Response to Planning Application

Application ref: P/38/21/PL

Description: Extension to existing agricultural barn. This site may affect the setting of a listed building & is in CIL Zone 5 (Zero Rated) as other development

Location: Little Sefter Farm Pagham Road Pagham

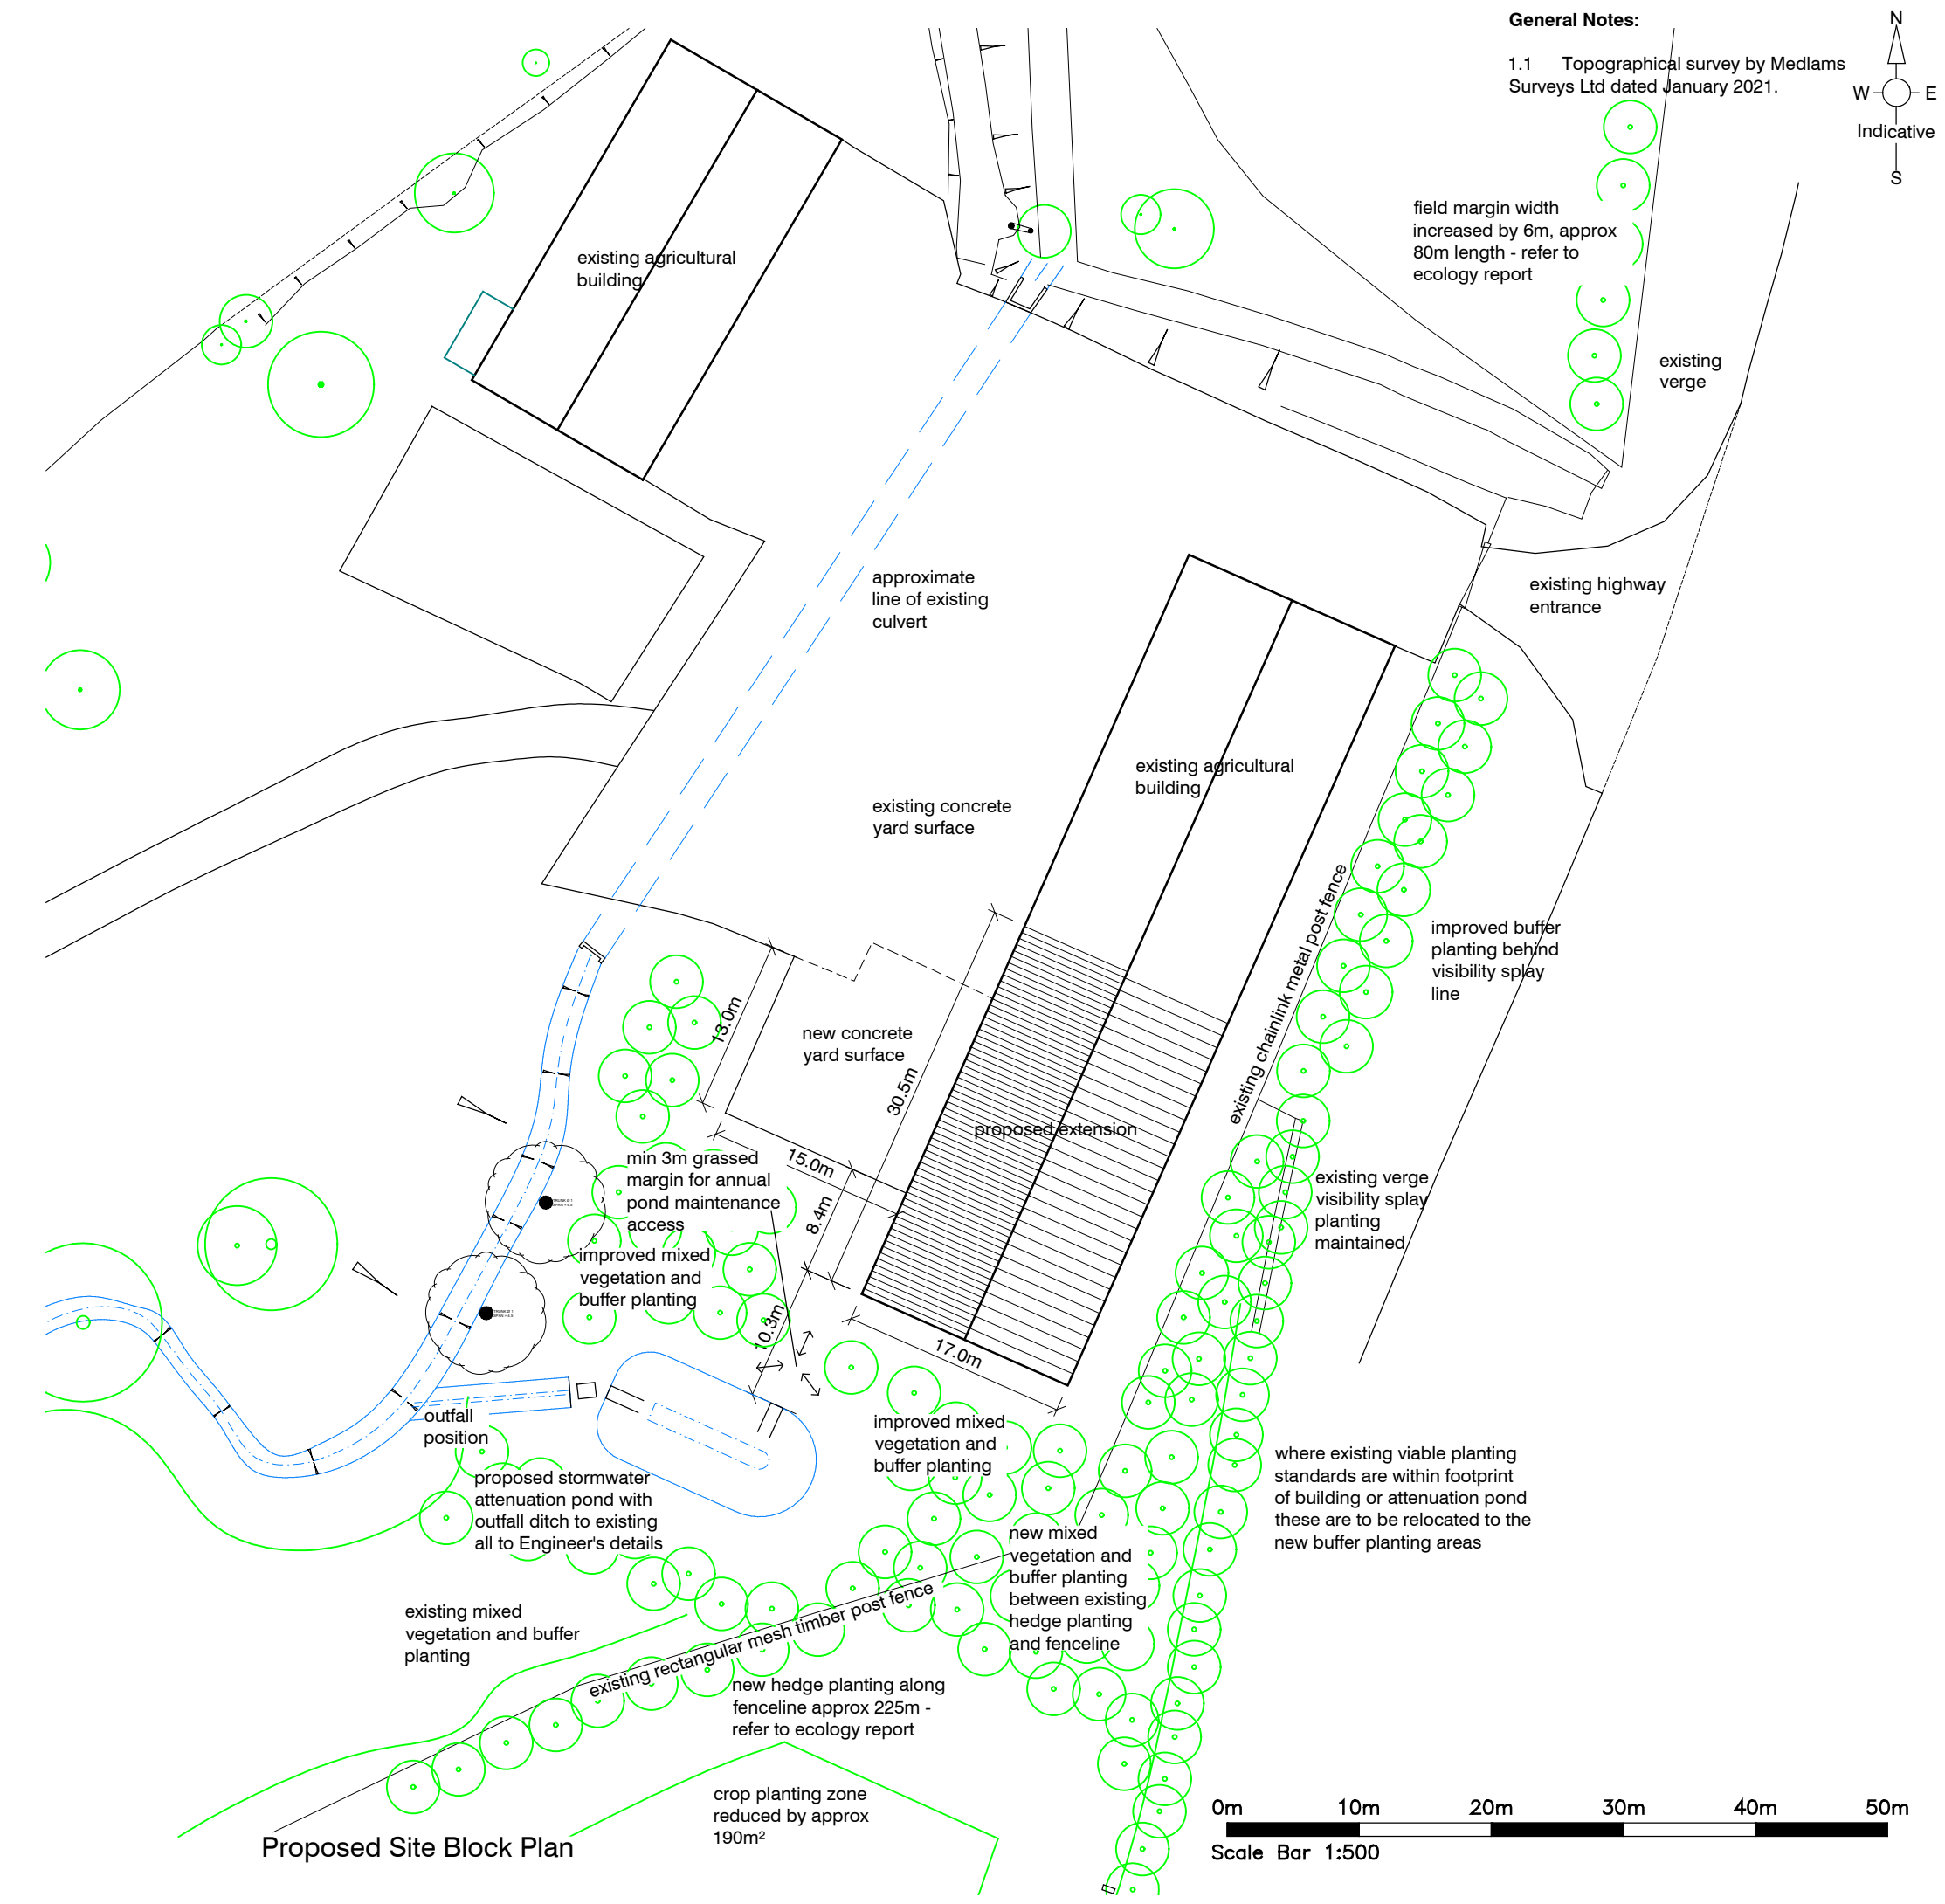
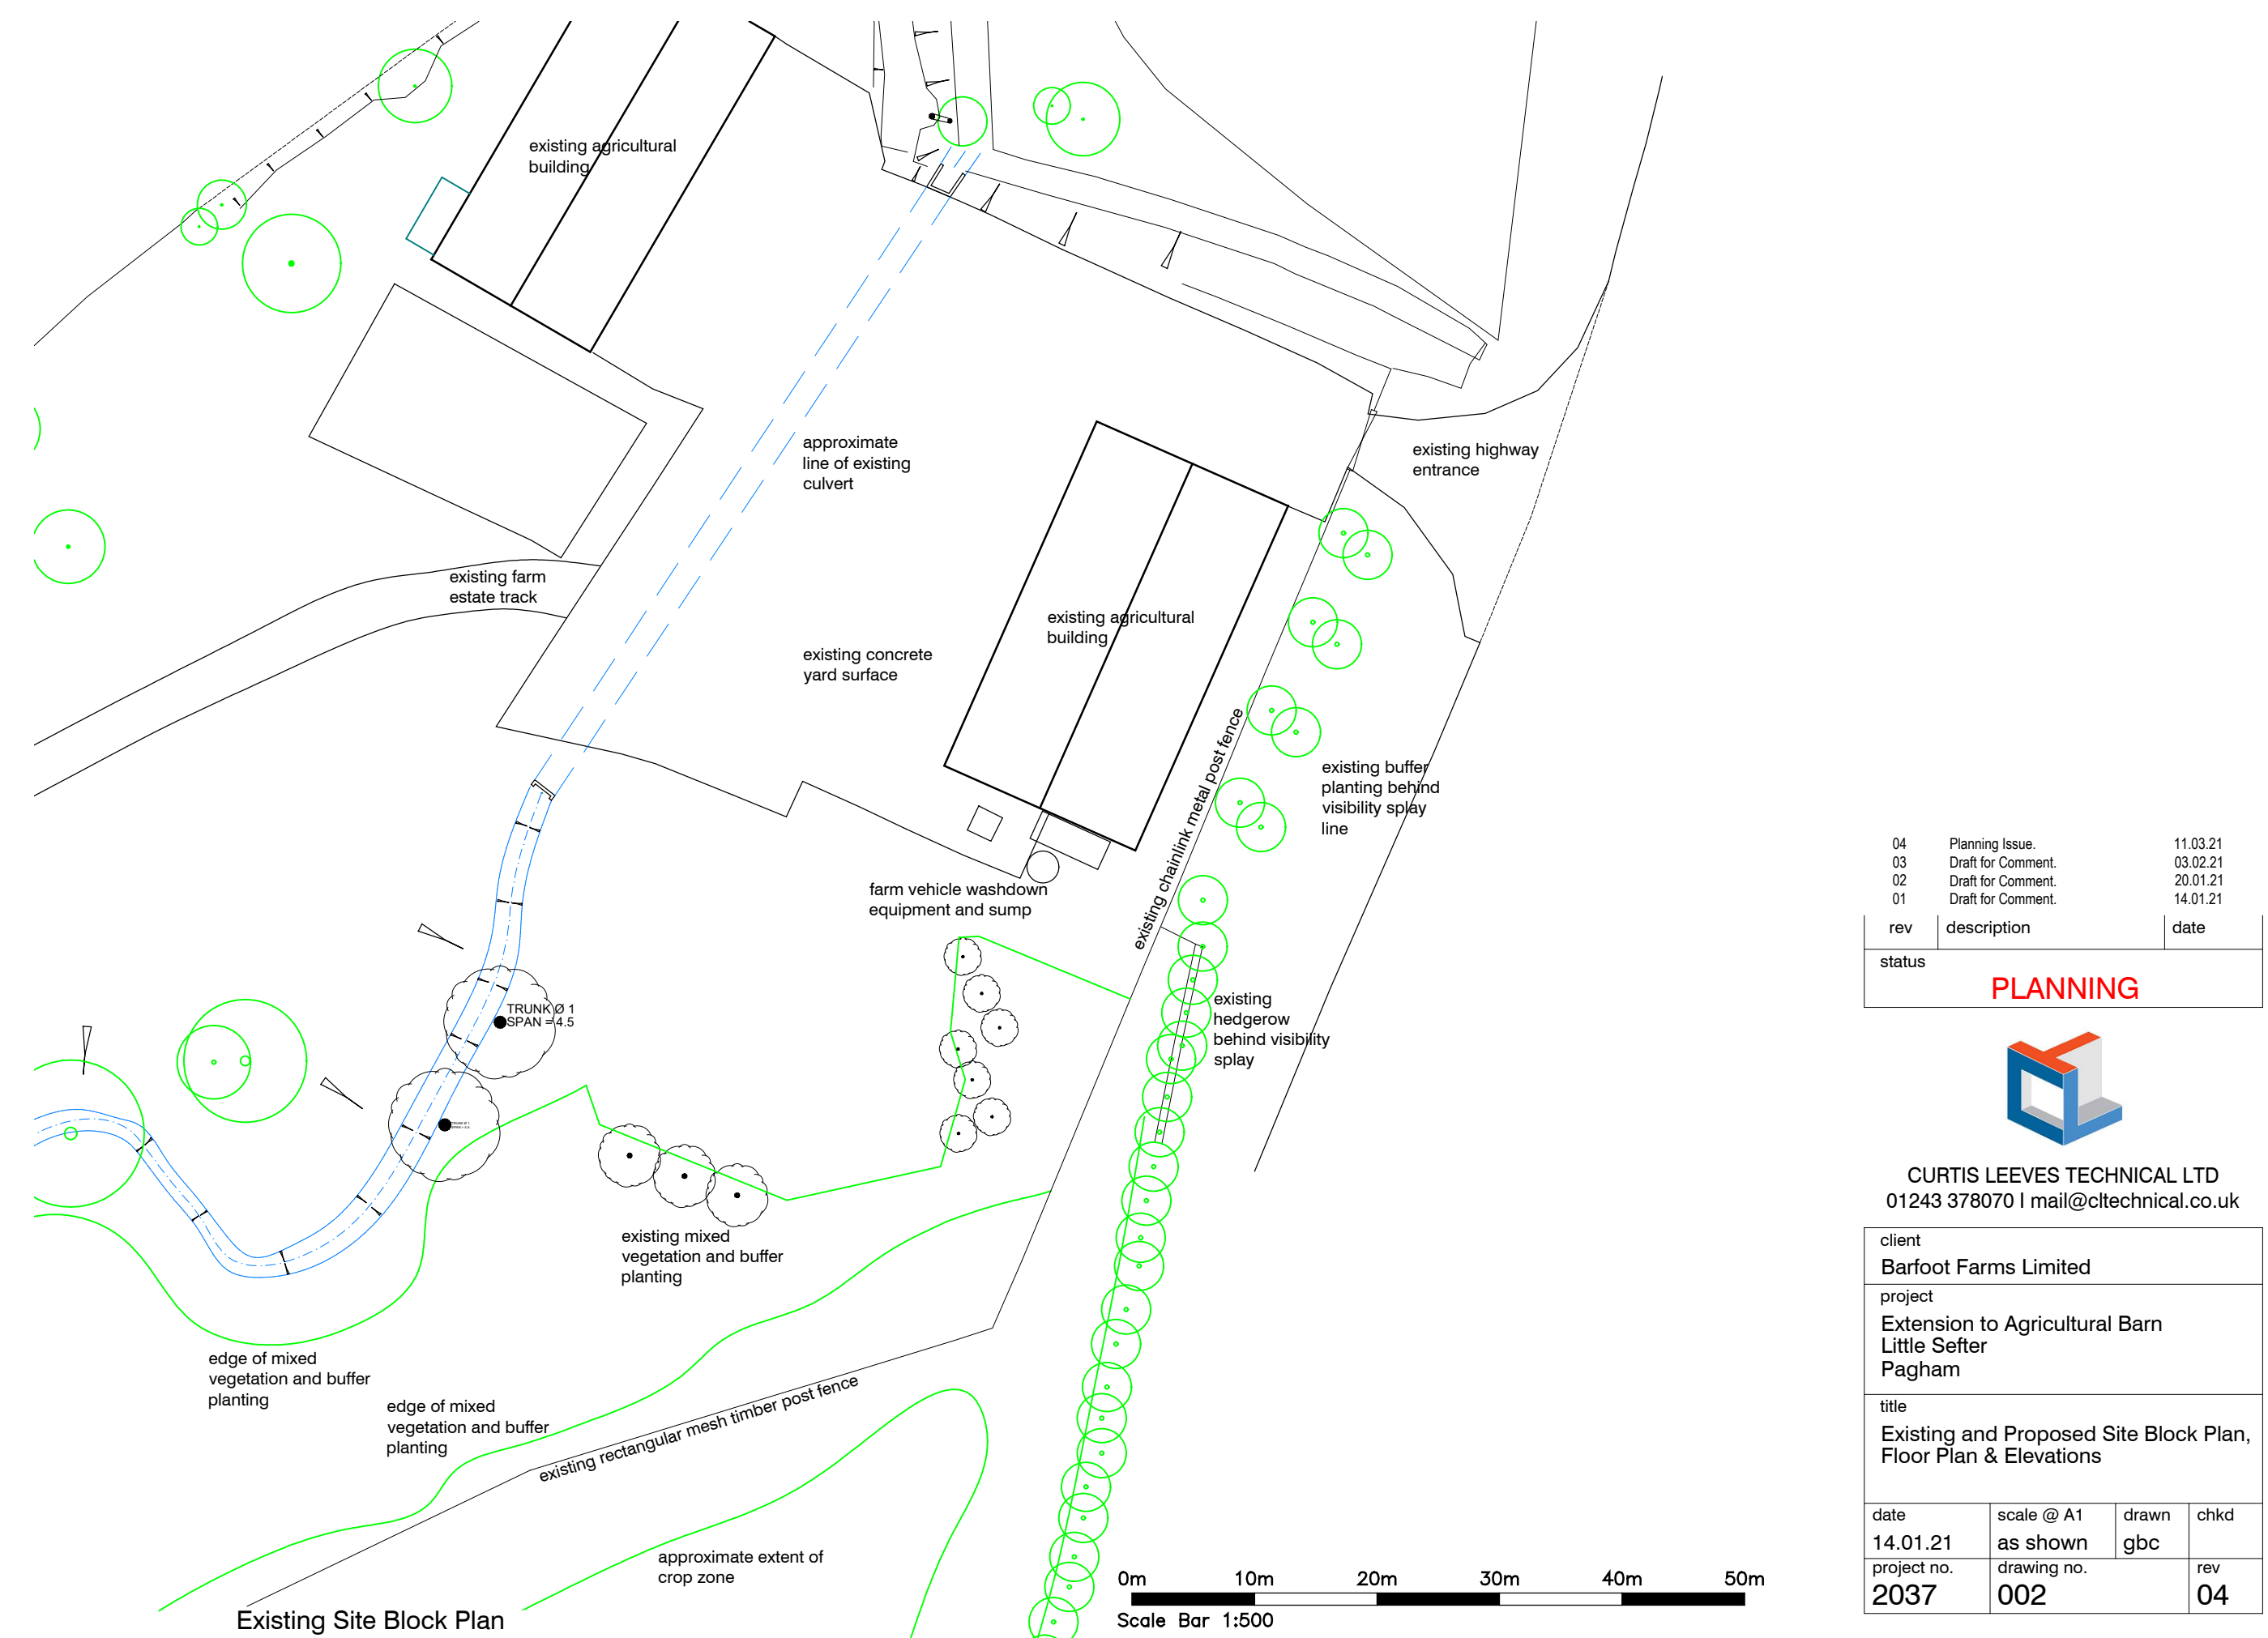
These proposals are for extension to existing, however the extension is at a scale that it would be visible from the road and surrounds and will require landscape mitigation to be implemented.

The existing and proposed site block plan and floor plan and elevations 002 Rev 04 dwg has shown indicative planting however this has not been shown in detail which would need to be submitted in plan form to clearly show planting species, actual quantities, planting densities and size at time of planting. The

mitigation planting will need to act as a buffer to both the exiting and proposed extension and help to screen from the road. The proposed planting would need to be at a size that provides instant impact and has immediate mitigating effect.

Advise landscape screening mitigation required for these proposals to be submitted in plan form with specific detail as above.
